**RE: Mesa Del Sol Self Storage
5500 Turing Dr. SE
Grading and Drainage Plan
Engineer's Stamp Date: 10/30/2024
Hydrology File: R16DA1004**

Based upon the information provided in your submittal received 11/01/2024, the Grading & Drainage Plan is approved for a **Grading Permit**. The following conditions need to be addressed prior to approval of a Building Permit.

C-1.0

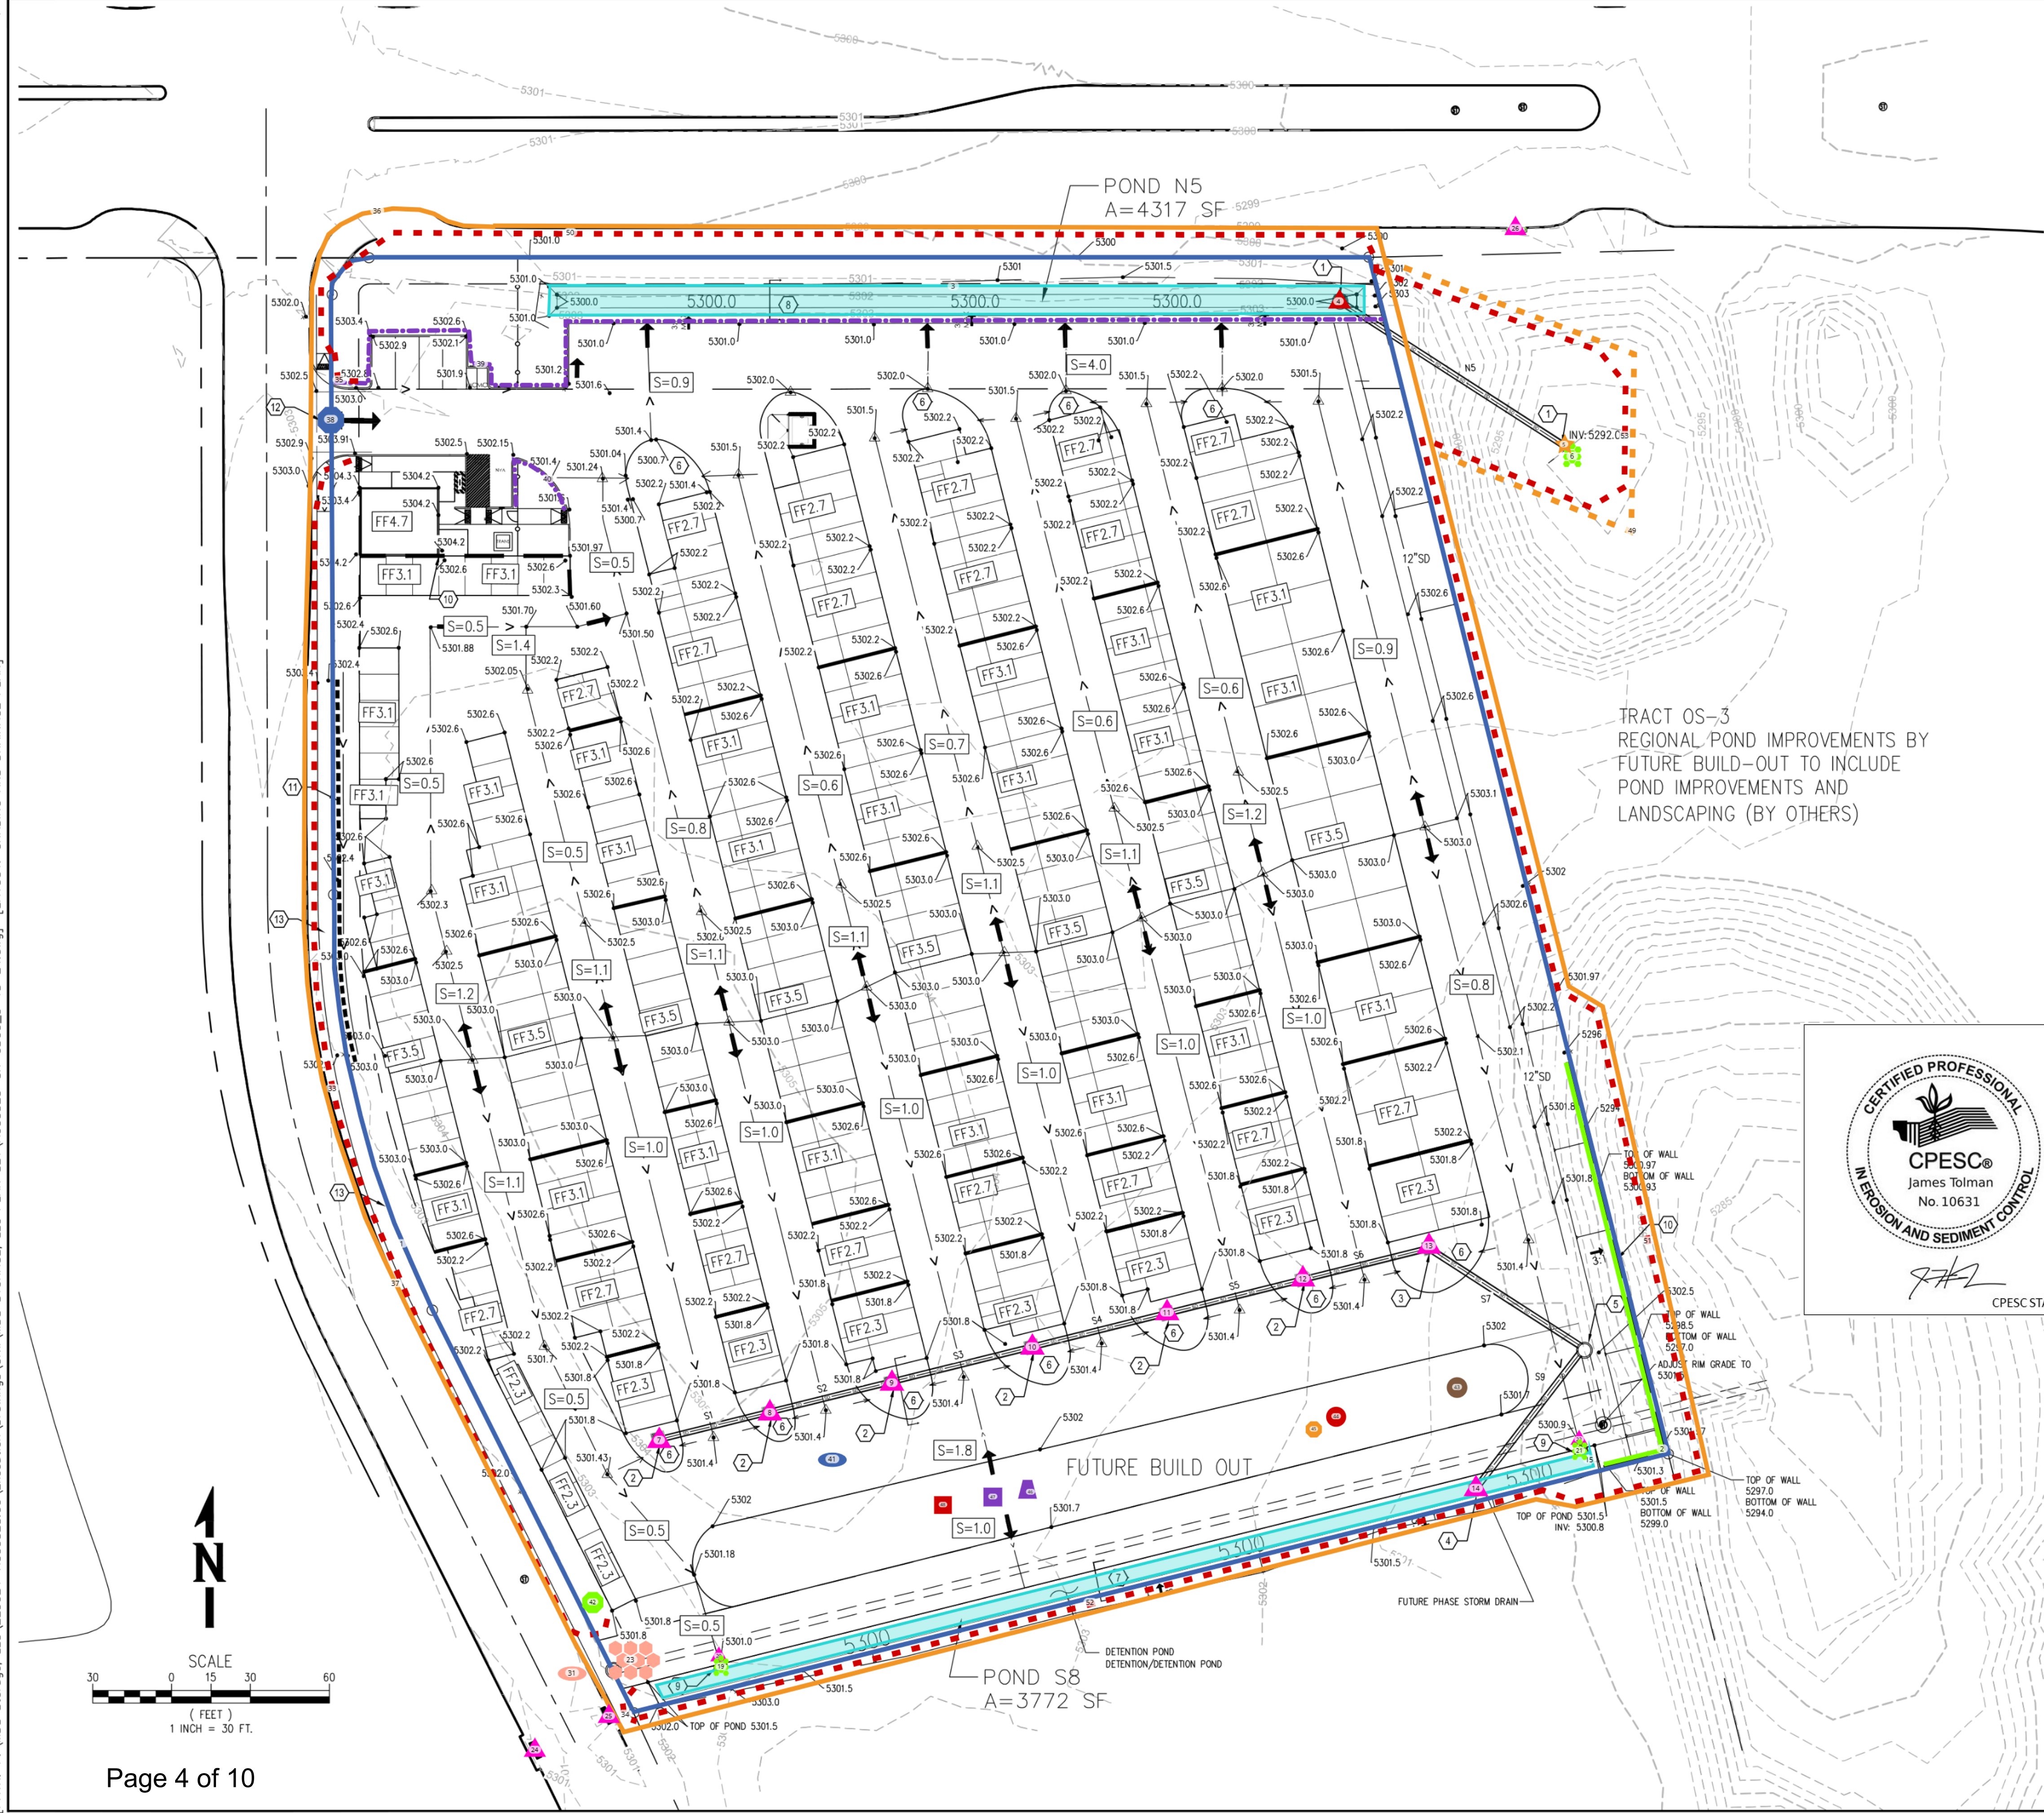
3. Provide sections through all external boundaries showing proposed retaining walls, garden walls, property/ROW lines, existing and proposed grades. In accordance with DPM Ch.22, section 5, part B. Grading and wall construction near the property line may not endanger or encroach upon adjacent property or constrain its use.

4. Provide cross-sections for the proposed retaining walls at the southeastern area of project and the proposed garden wall at western area of project adjacent to the proposed sidewalk.

5. Please add a note in the cross sections, "Floodproof the retaining wall below the 100-year 10-day volume water surface elevation per the City's specifications."

6. Provide erosion protection at all locations of proposed improvements and particularly at outfalls into existing ponds.
7. Confirm that the pipe invert elevation discharging into the northern pond will function with the record contours shown. Over time, rainfall events and sediment may have reduced the capacity of the existing ponds.

8. Provide current elevations at top and bottom of earthen ponds to demonstrate or confirm stormwater capacity of existing ponds to accommodate runoff into ponds per the stormwater Master Plan.

4 POND N5 CROSS SECTION
SCALE: N.T.S.

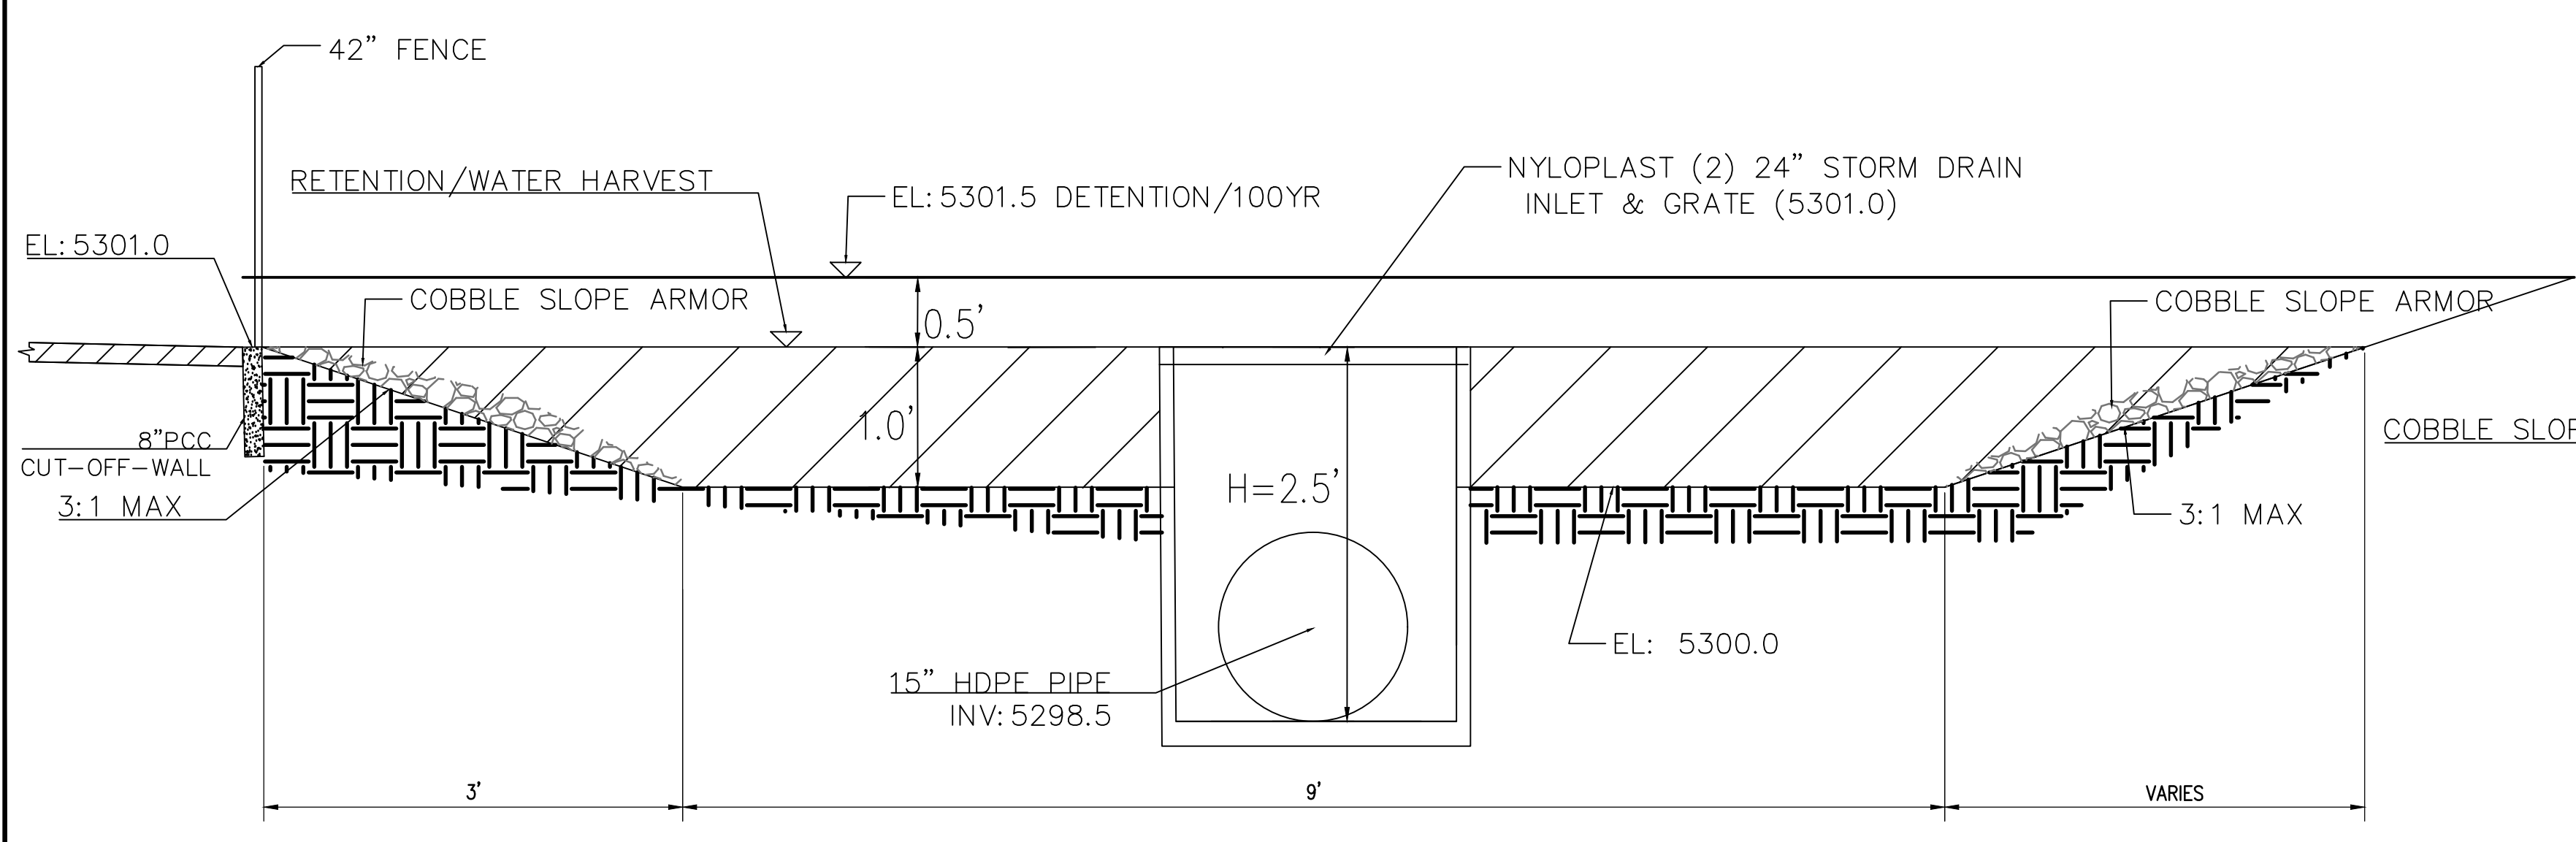
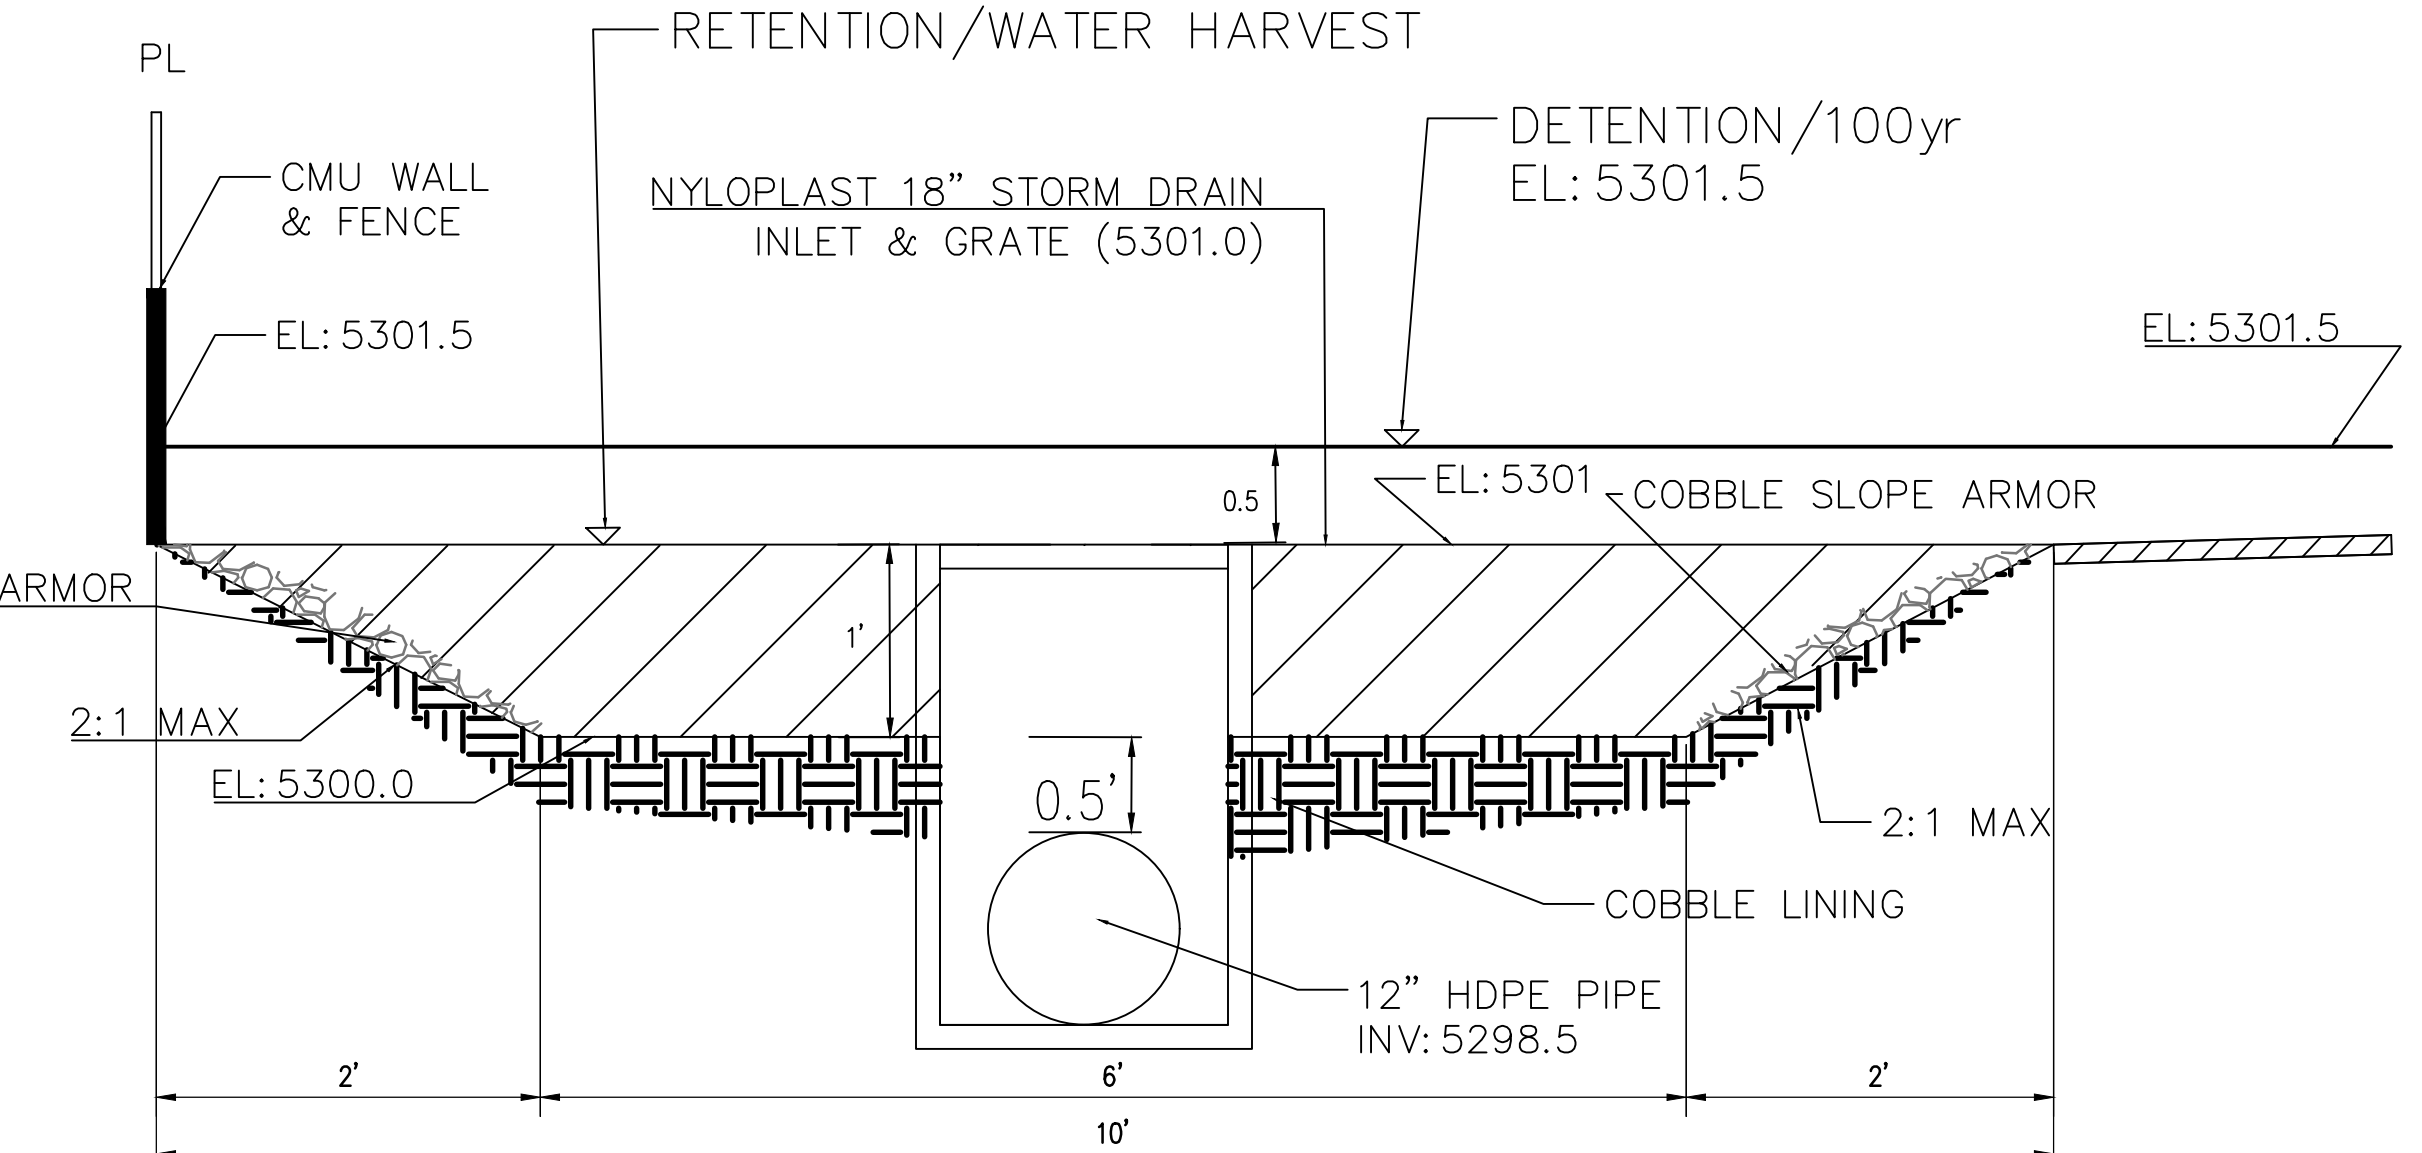
1. Provide reference to Civil Detail Sheet C-2.0 for Keynote No. 8, Pond N5 Cross Section, Sheet C-501. Include erosion protection along pond alignment to maintain capacity.
